2023 Financial Assurance Estimate Form
(with pre-plat construction)

PROJECT INFORMATION		
MARIAH TRAIL FILING NO. 1	8/4/2023	SF2315
Project Name	Date	PCD File No.

**SHEET NO.:**  
GEC-1

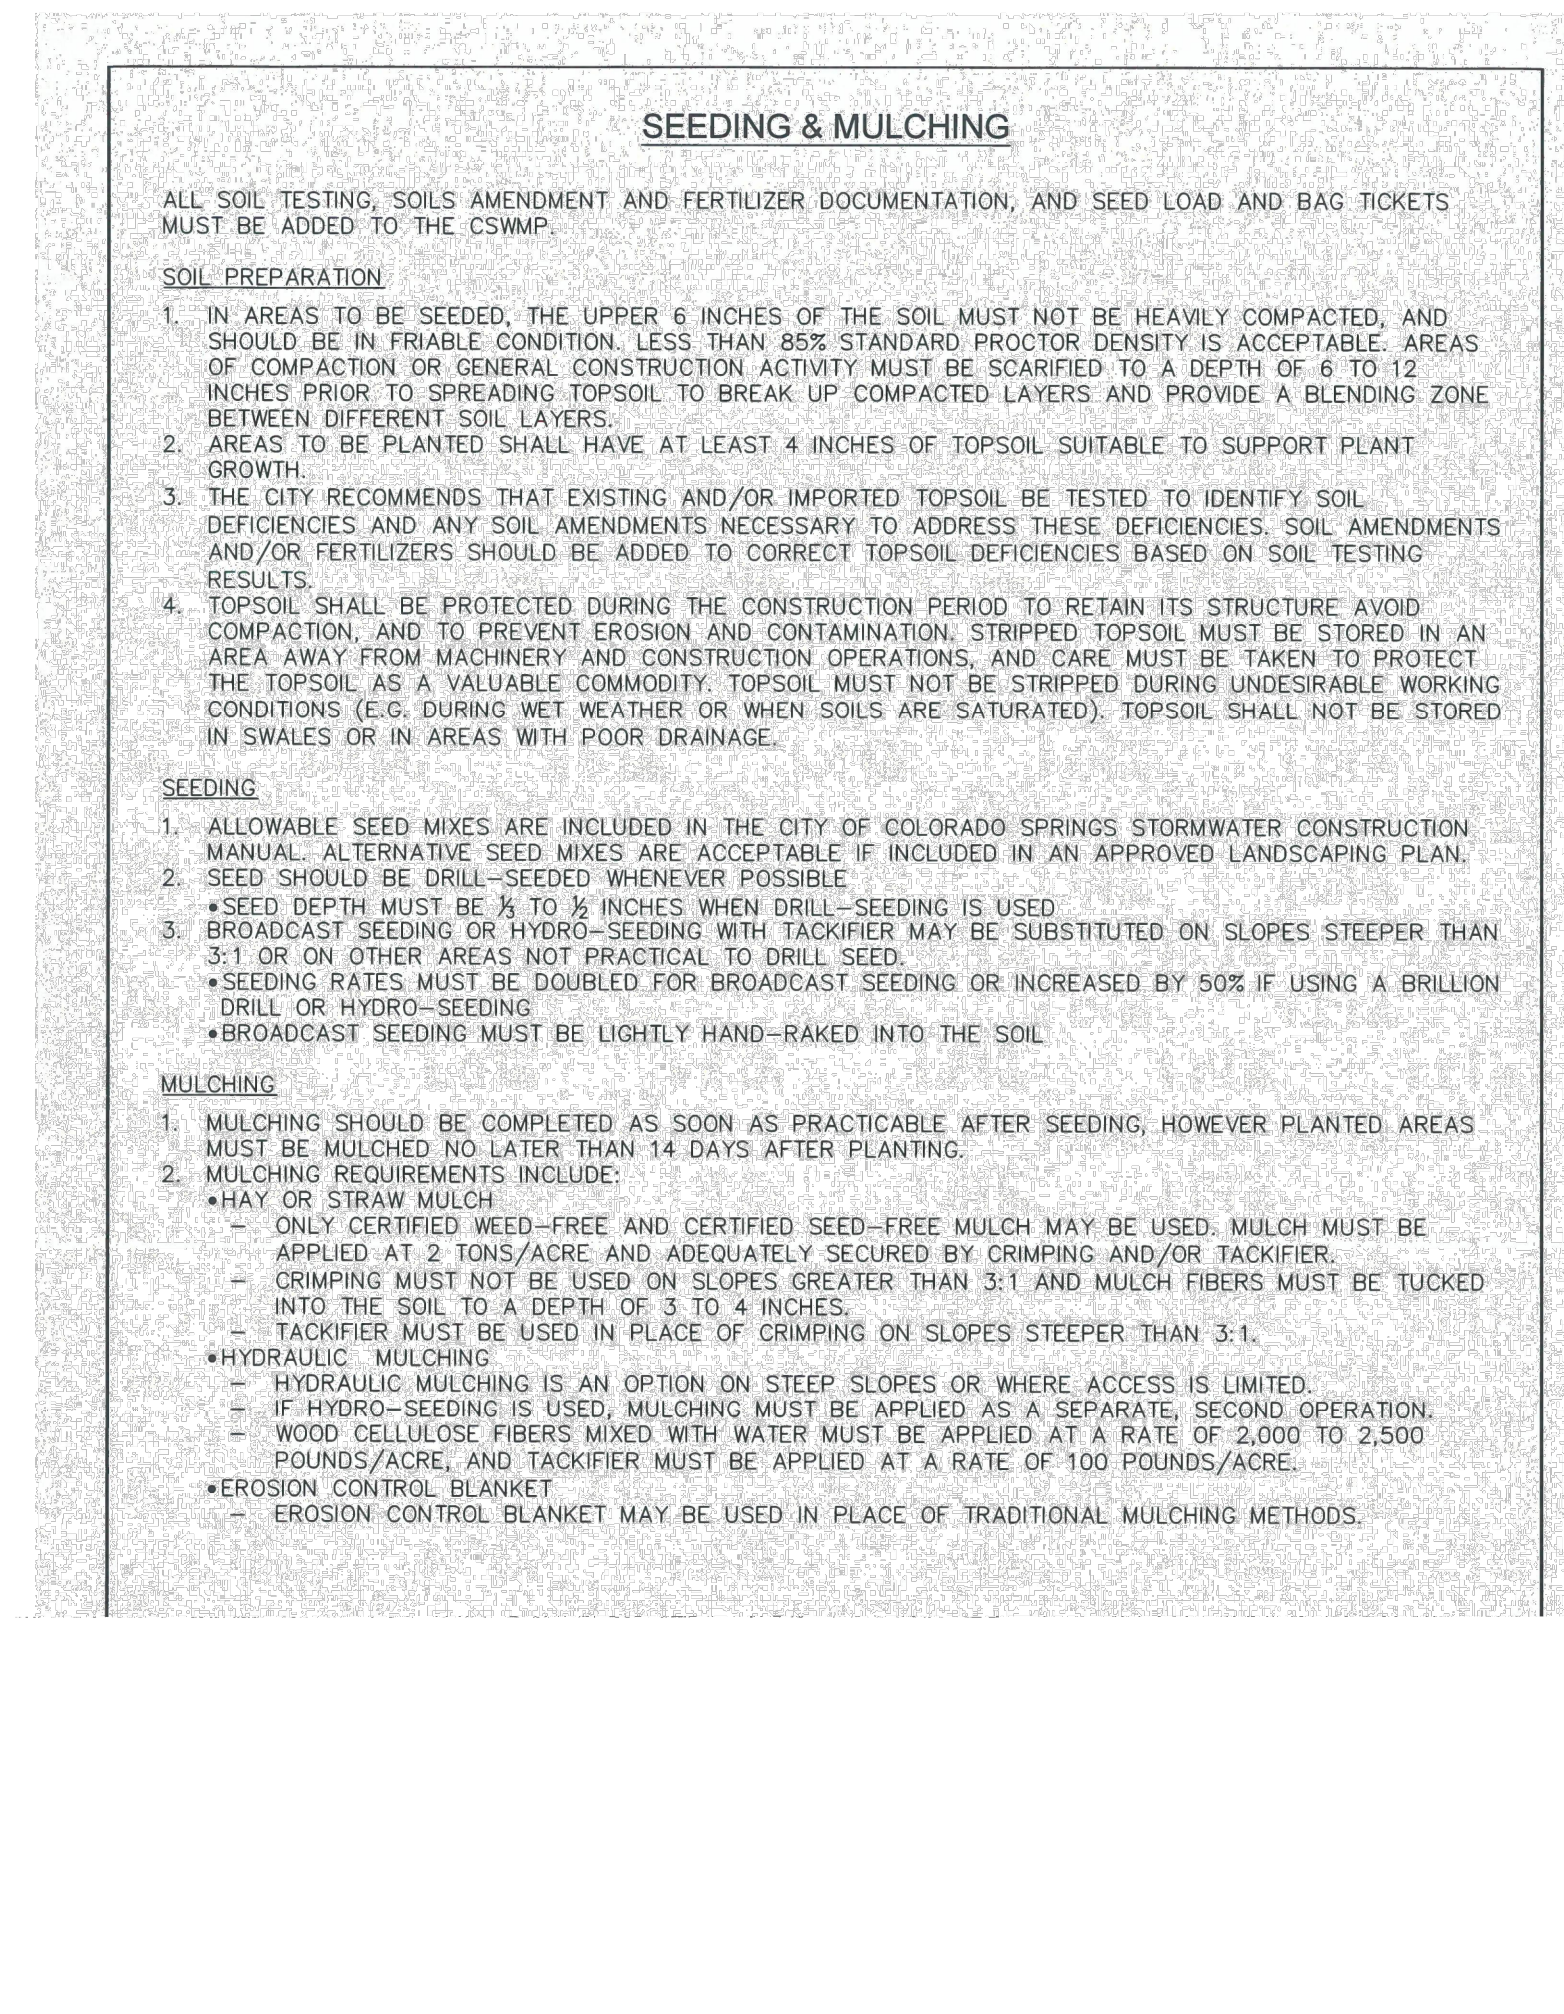
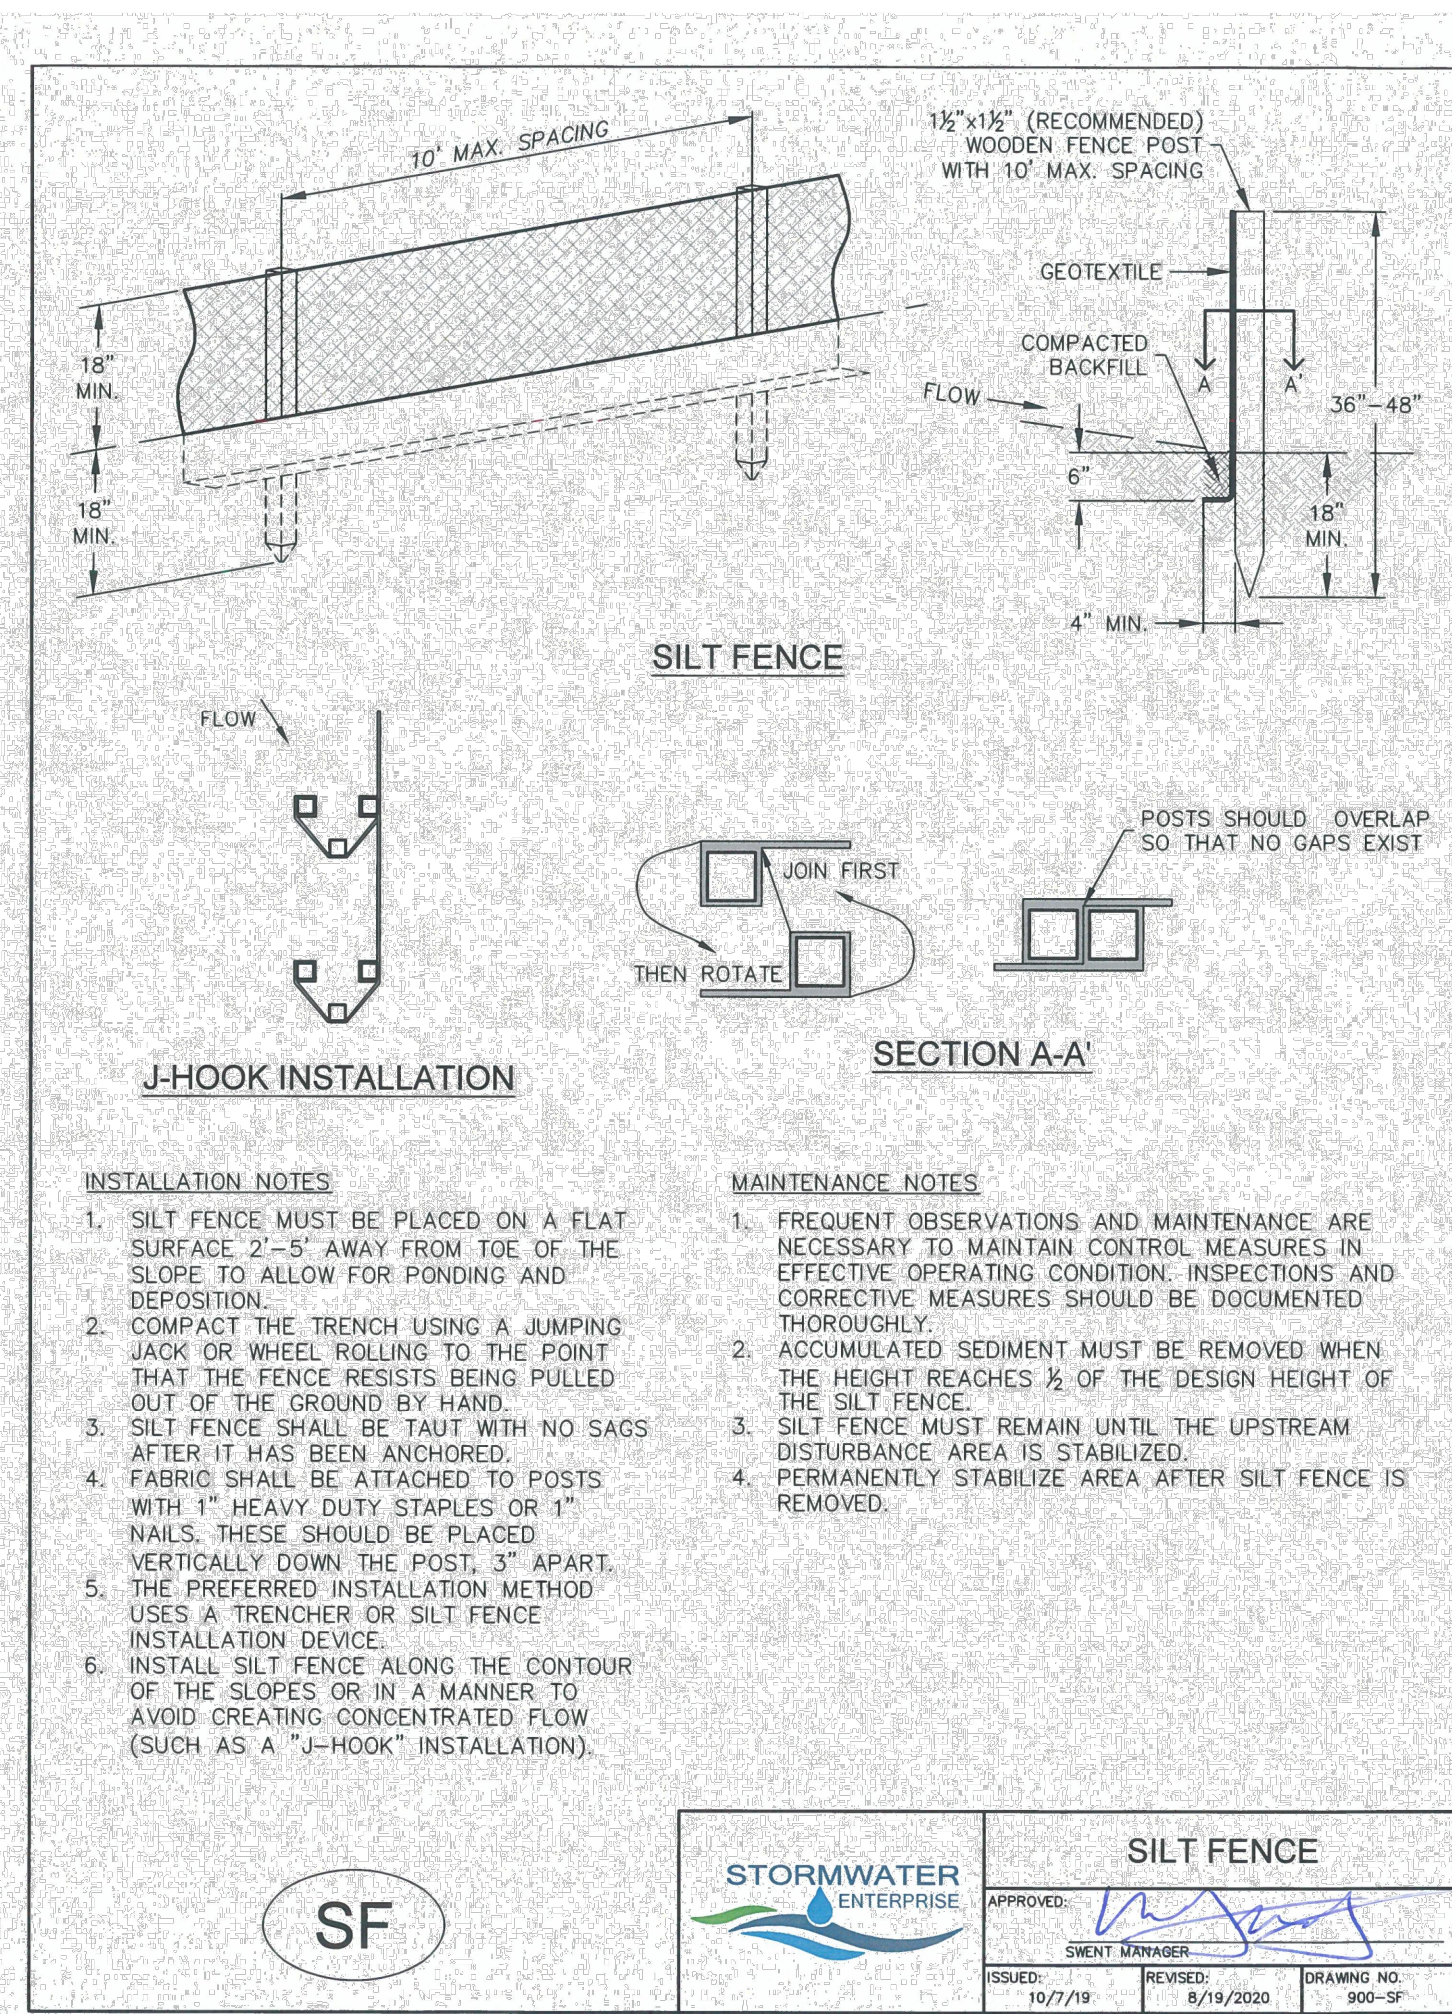
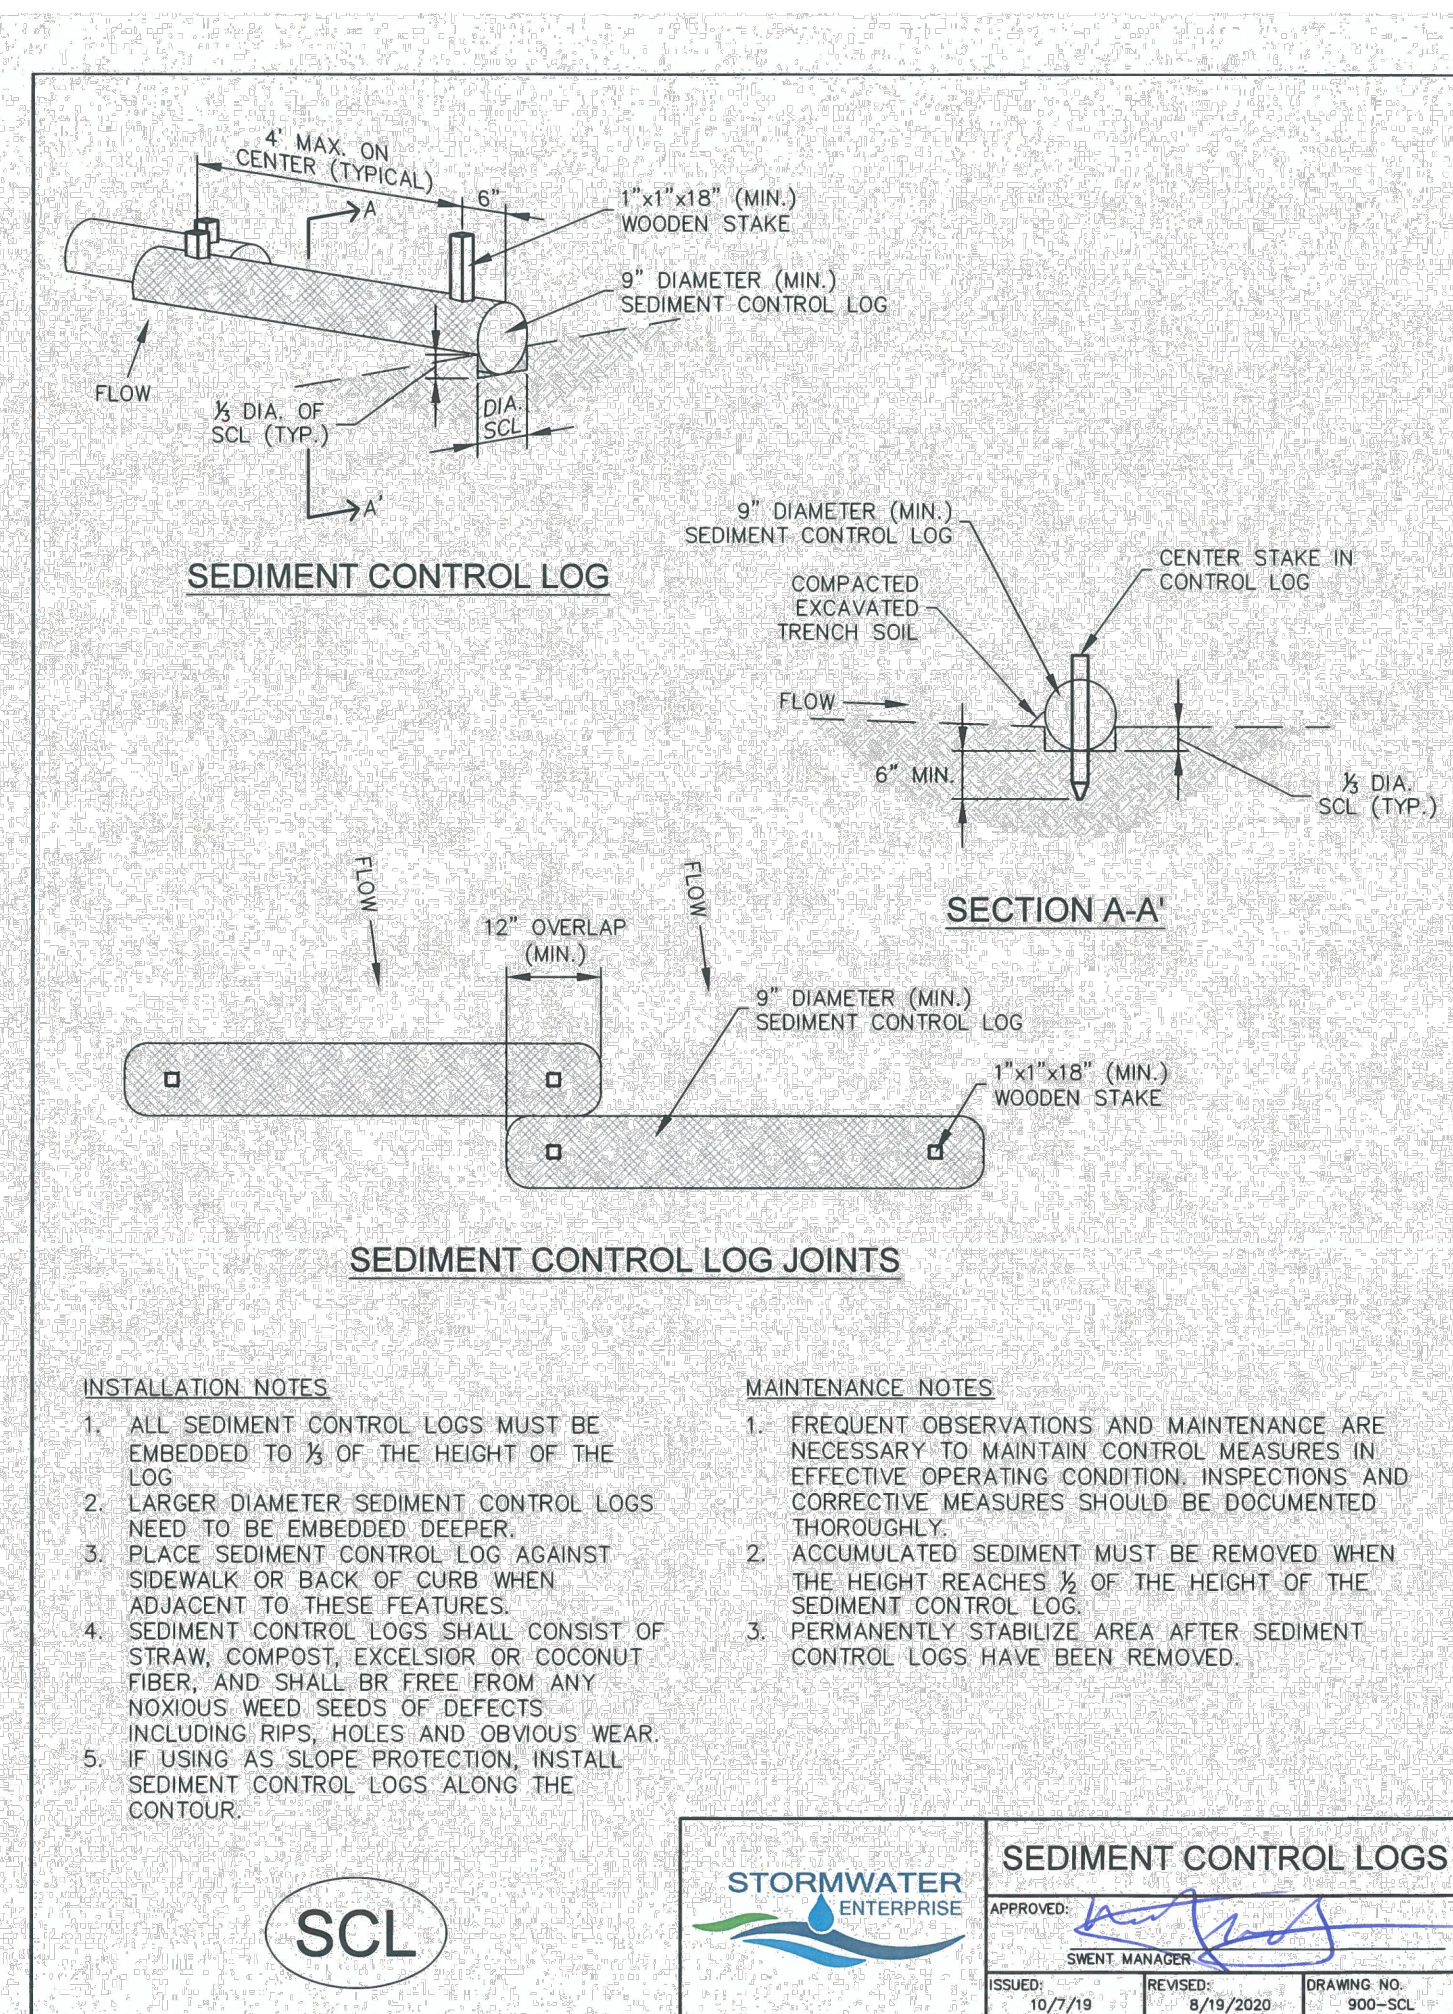
Show CWA on GEC Plan or remove from FAE if unnecessary

Seeding and straw bale barriers not shown on the GEC Plan
